Your Refs 2021/92116

Regards the proposed plans for 23 Fall Lane, Hartshead

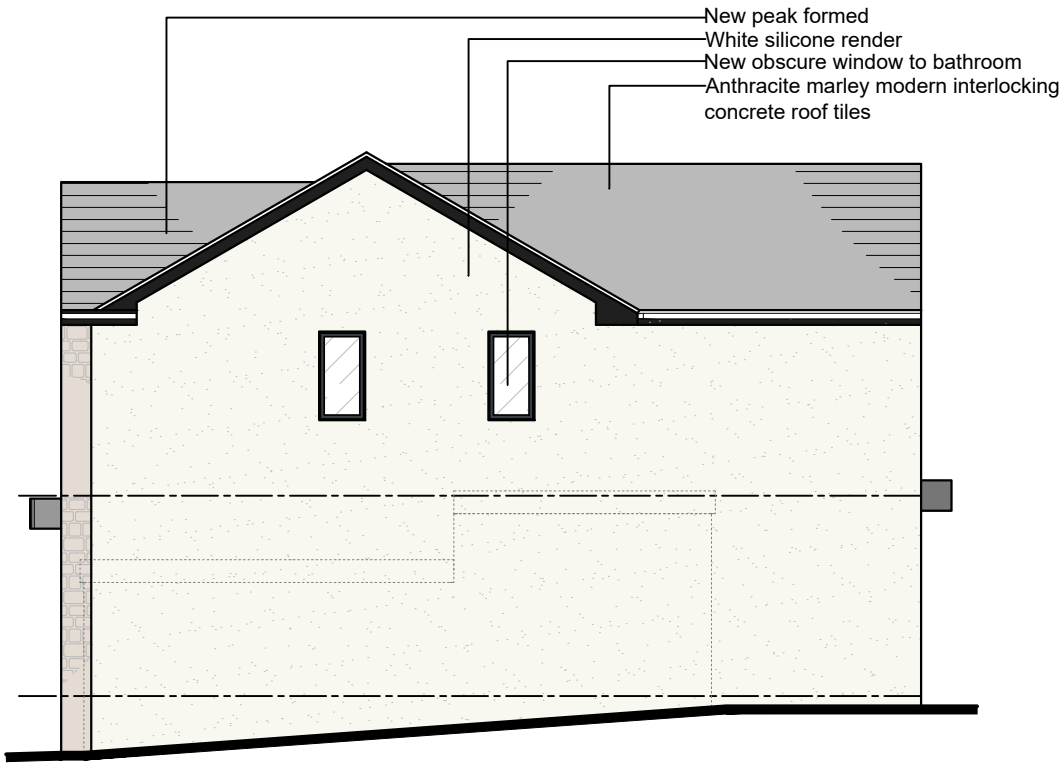
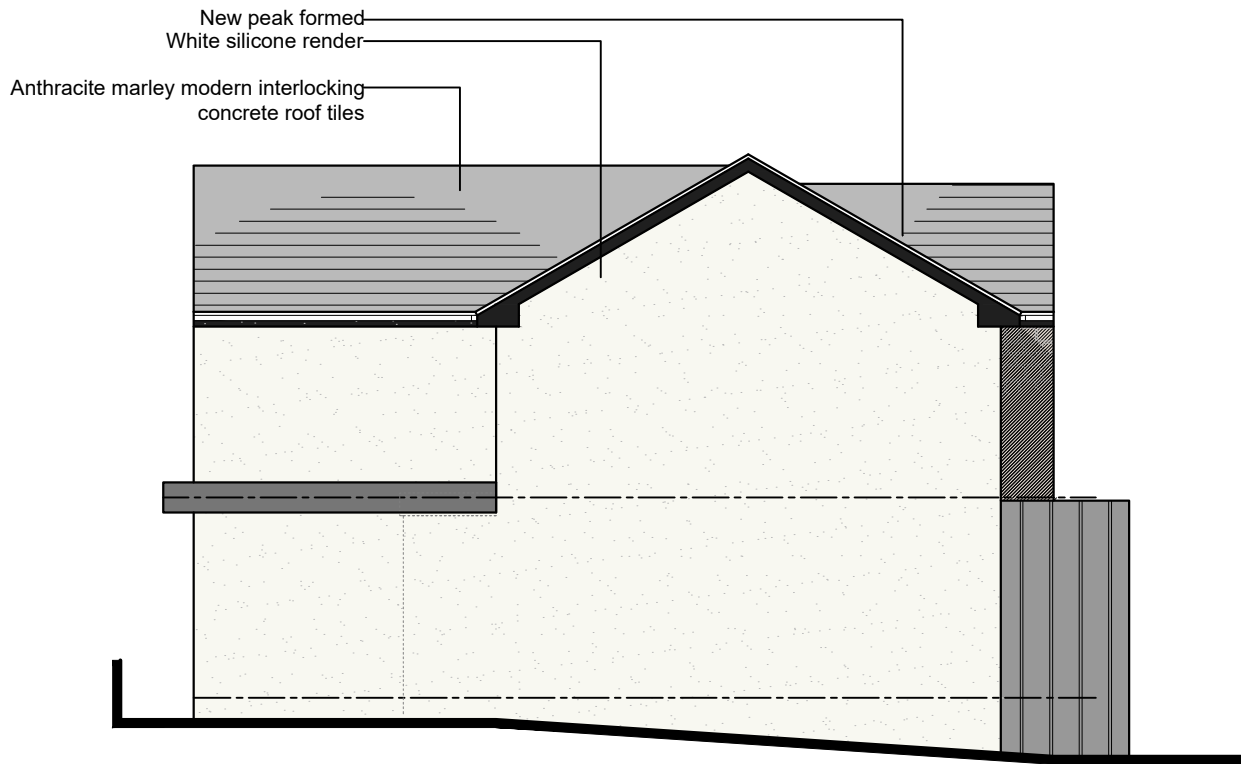
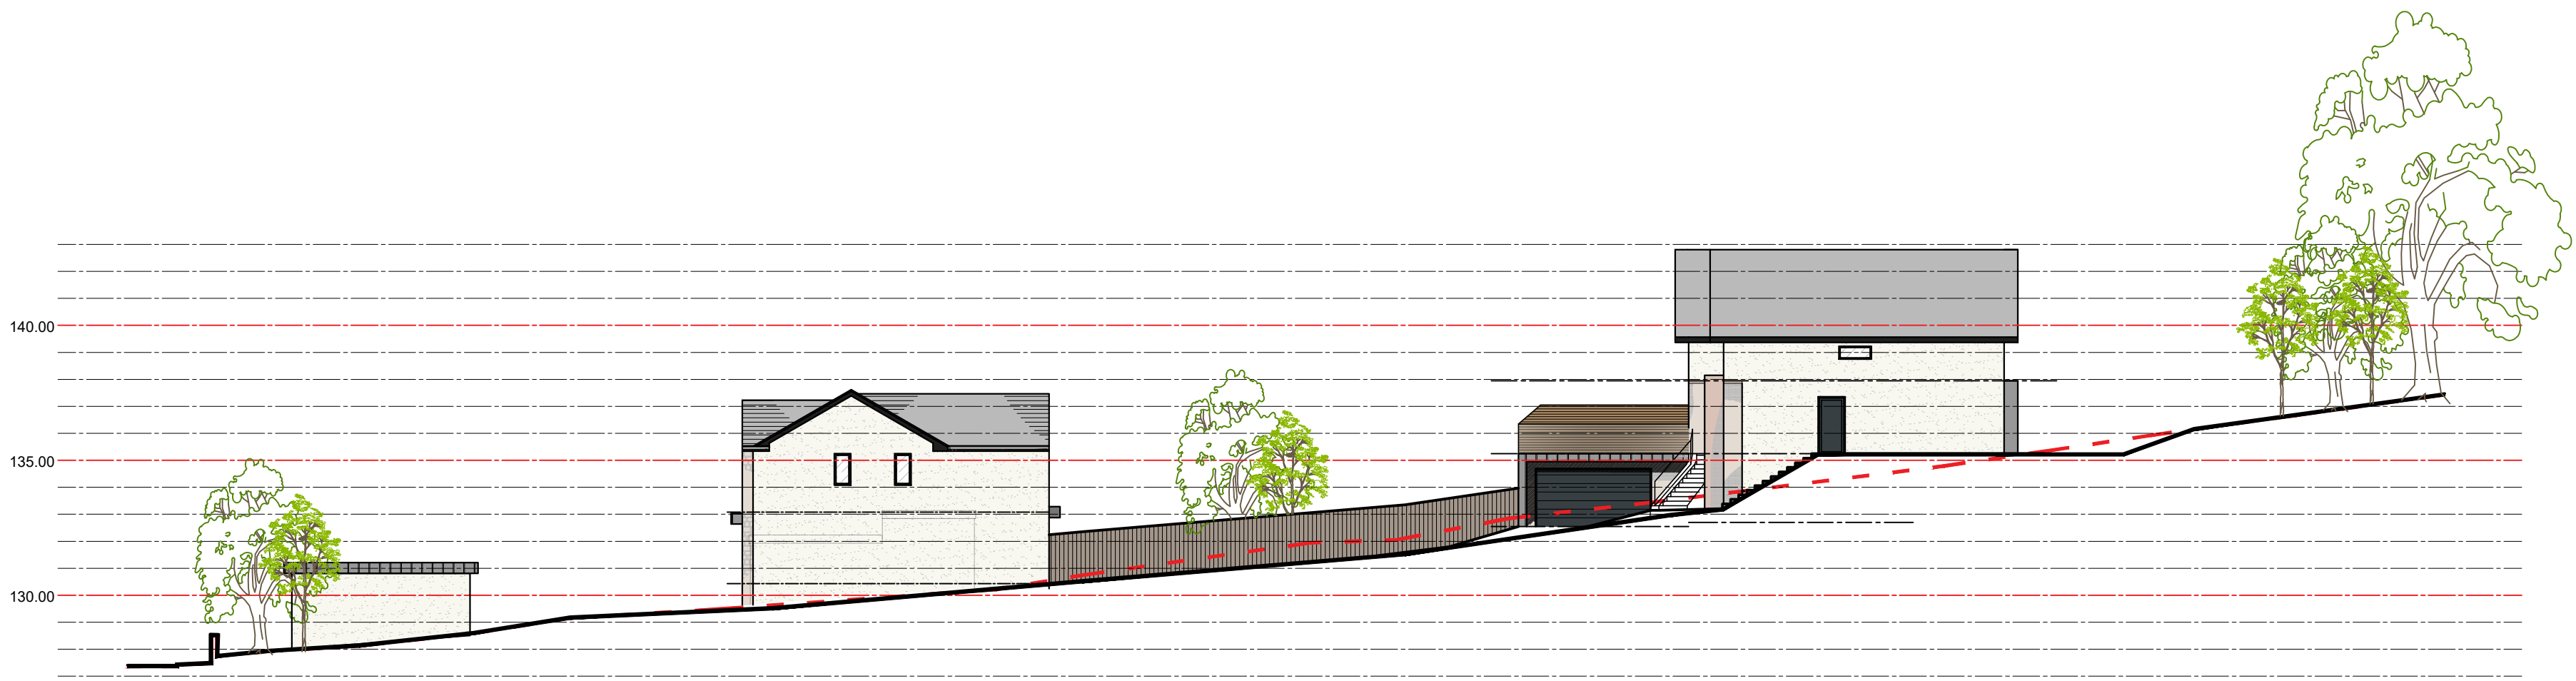
- 1. The erection of a detached dwelling and access road is an over development of the site.**
- 2. The proposal for a 3-storey building is too large, especially as it is on an elevated site. The building will impinge on my and my neighbour's privacy. As the number of windows facing towards adjoining and nearby houses give a clear line of vision into all the surrounding houses, bedrooms, and garden removing all privacy.**
